Application for Planning Permission

Demolition of existing single storey side extension and construction of an attached two storey self contained dwelling.

2 Worcester rd, planning re-consideration

28/07/2022

FIRST FLOOR PLAN

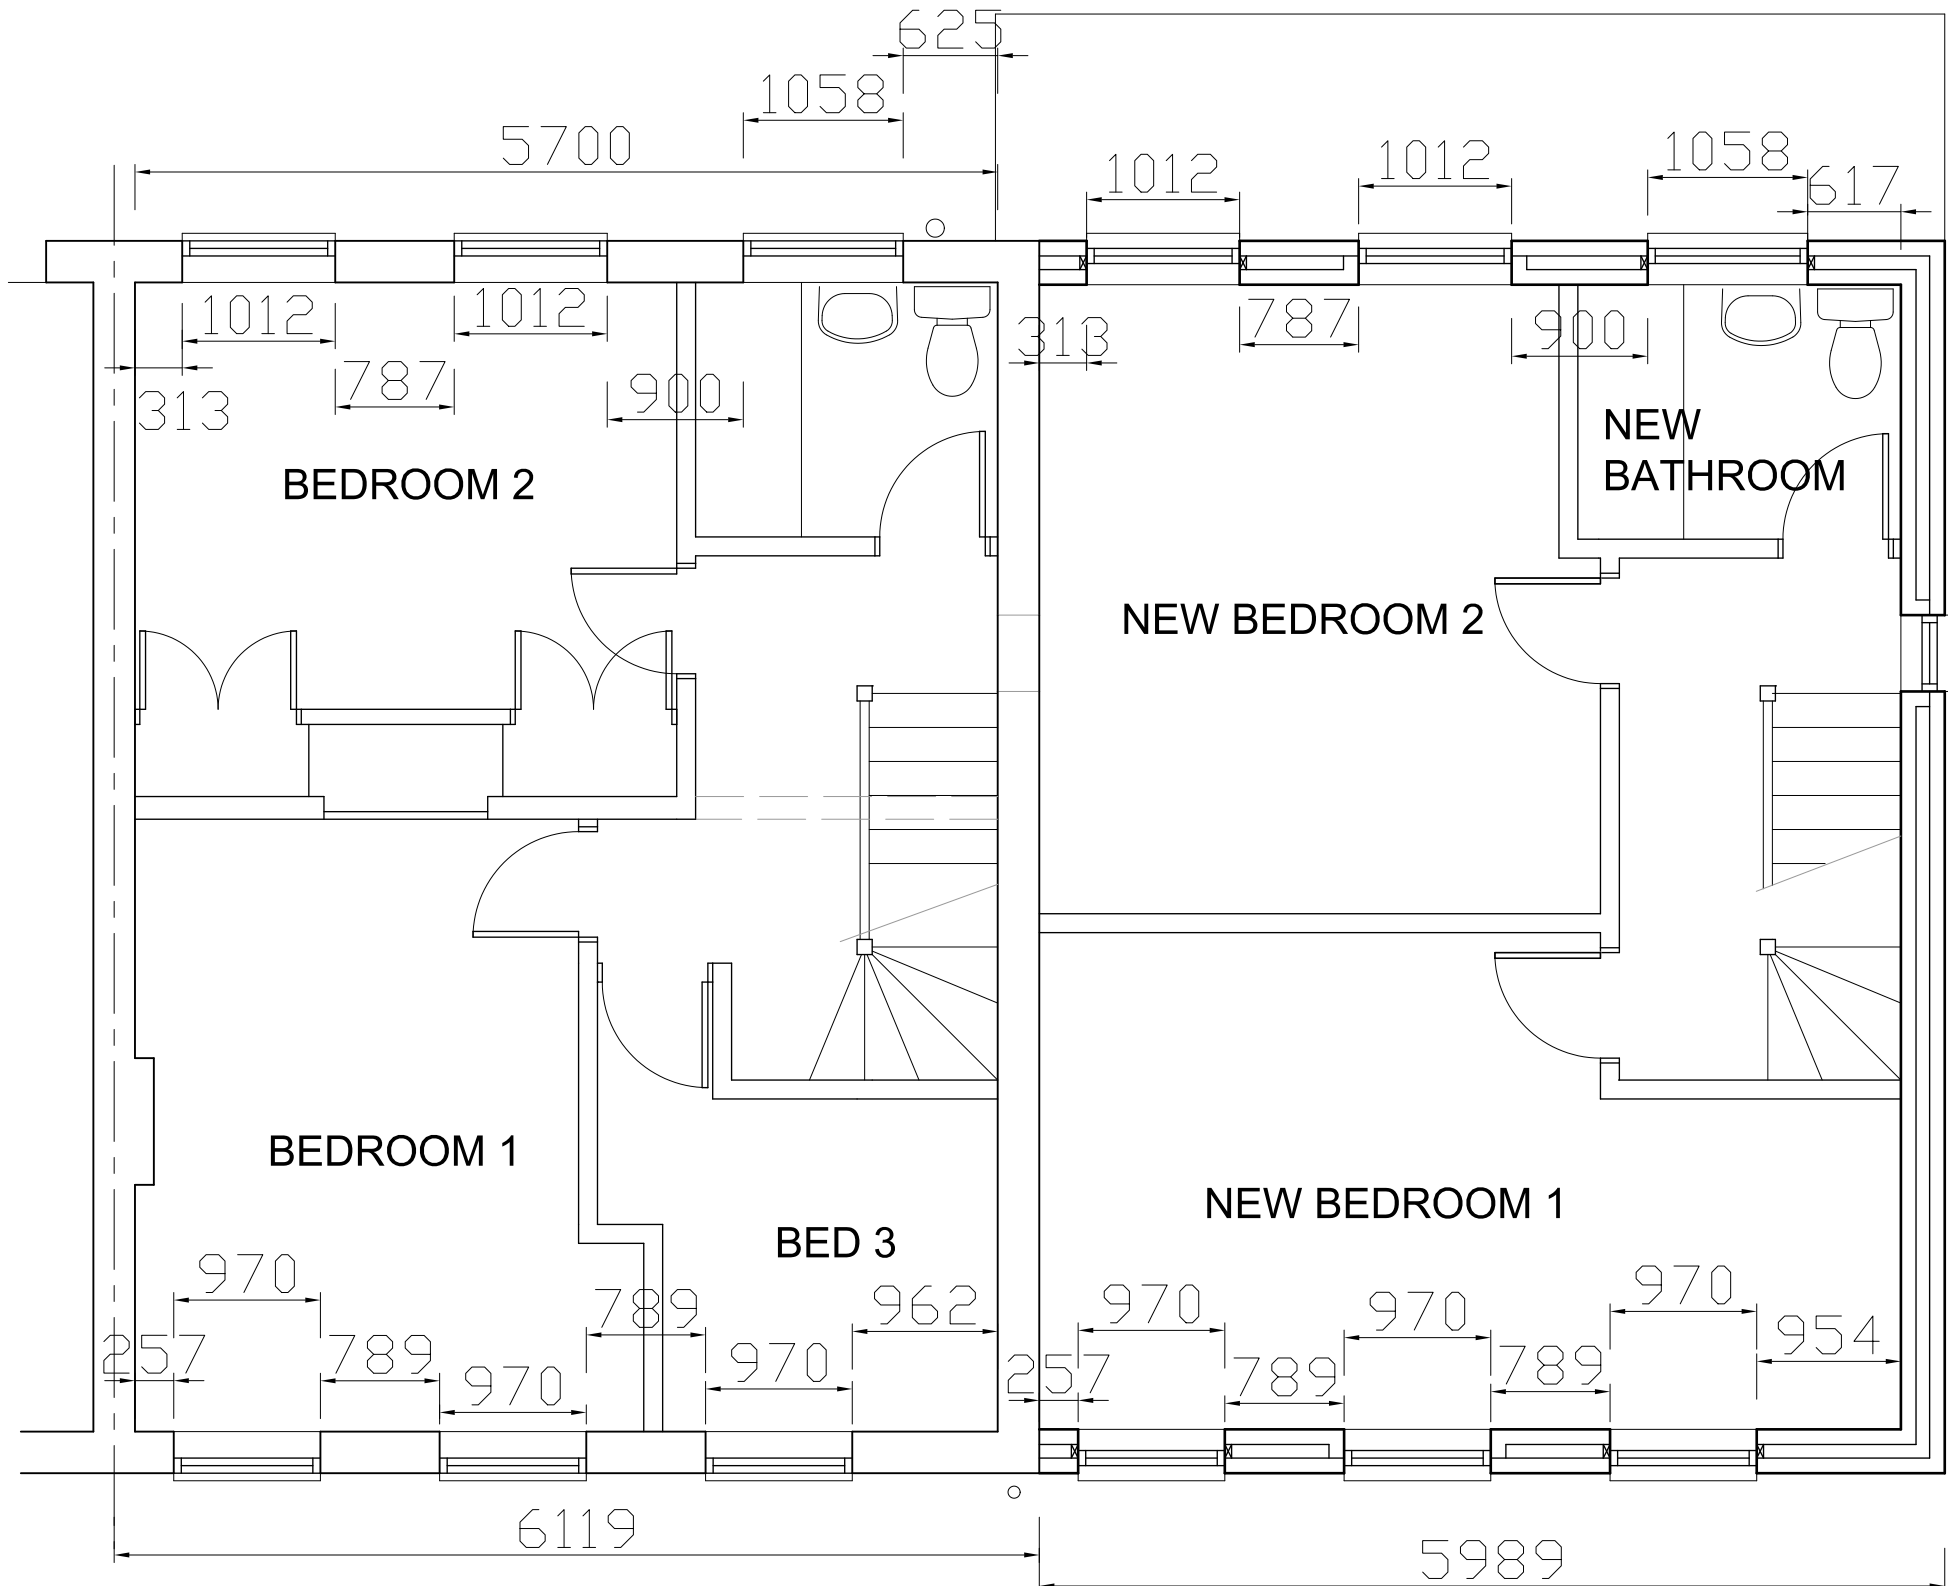
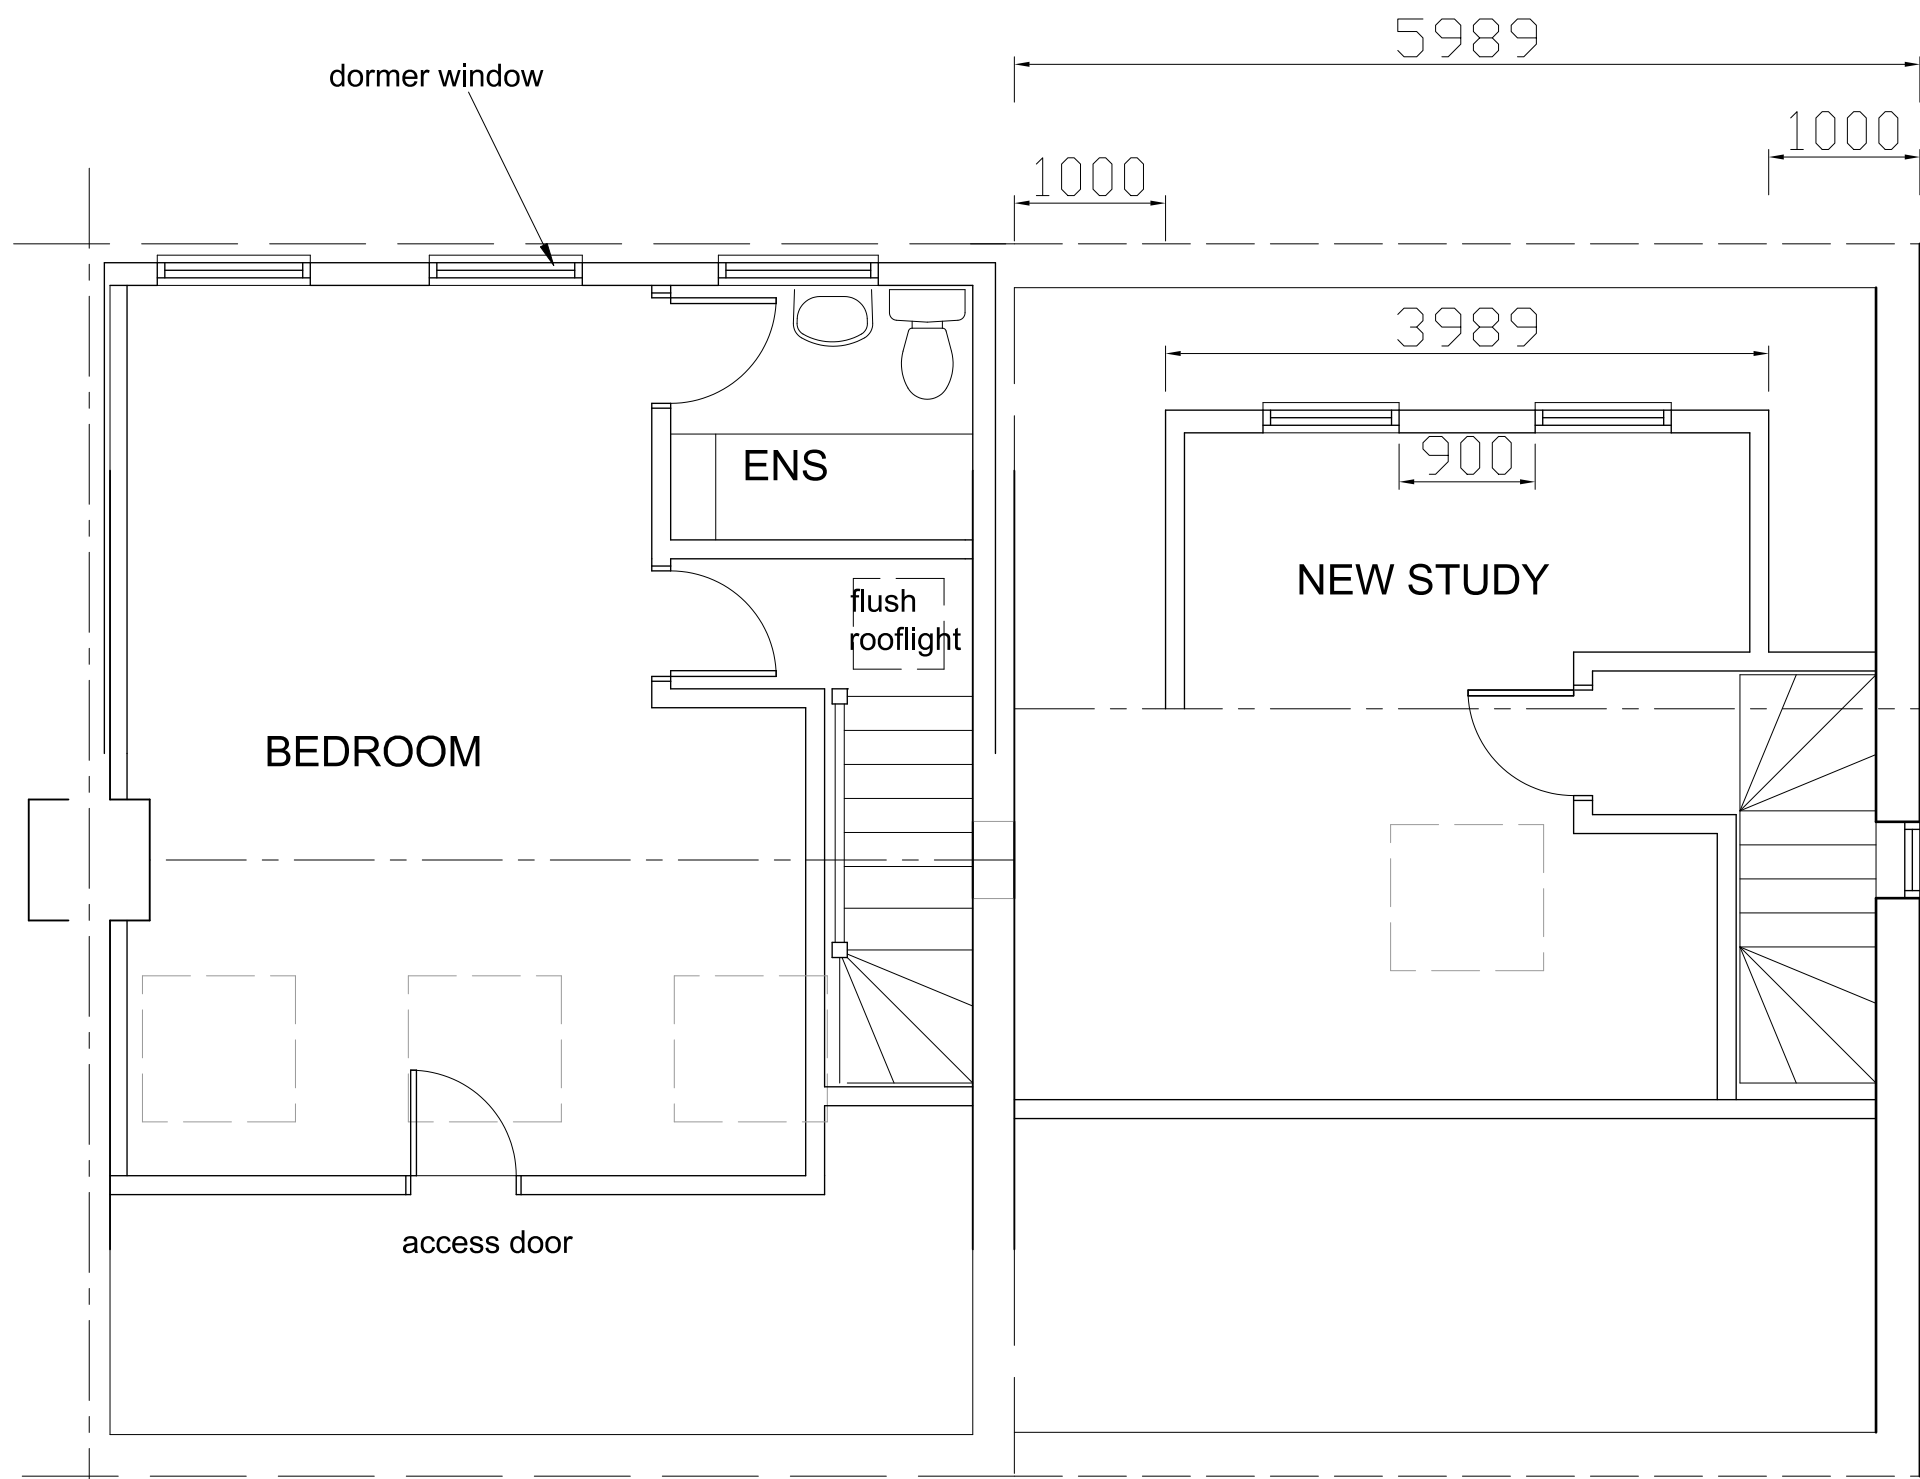
We would accept a reduced set-back but this means you will need to provide refuse storage in the front garden since there'd be limited access to the rear down the side.

We would accept 1 parking space for the new two-bed dwelling. This would be in accordance with the local plan where only one would be required for a one or two-bed unit. The existing 3-bed would need to retain the 2 spaces.

I have reviewed the previous refusals and two appeal decisions. My recommendation for an application that may be looked upon more favourably is to replicate the proportions, scale and appearance of the existing dwellings. Specifically this would be:

- The new dwelling needs to be attached to form a terrace. The street is characterised by consistent spacing between the pairs of semi-detached homes. A detached dwelling cannot duplicate this given the plot width.

- The plot width of the new dwelling should be the same (or as close as practicable so that any variation is visually negligible) as that of No. 2 and the other dwellings on the road. This means that the new home width would be the same as the other dwellings and the appearance can be duplicated with the same three windows, same ground floor fenestration etcetera. In other words the new home needs to look exactly the same. However it is important that the side elevation is not splayed, this would be too conspicuous in the street scene. It needs to be straight like the other dwellings.

- As with the advice above, the front building line and the principal rear building line needs to be the same as No. 2 so that this reads as a terrace of three dwellings. It may be possible to add a small single story rear extension and small rear roof dormer if additional floor area is needed to meet minimum GIA requirements.

- The materials, fenestration design and overall design needs to match the other adjoining and adjacent dwellings.

- You use the existing dropped kerbs and don't seek to widen these
- There should be enough clearance within the forecourts of both dwellings for pedestrians to access the entrance to each house
- Ensure that the garden space for both homes complies with at least 60sqm (for a 2-3 bedroom home) or 100sqm (4+ bedrooms) and are genuinely usable and of good quality. These should take the form/layout of a standard lengthy rear garden to mimic the typical garden layout in the area.
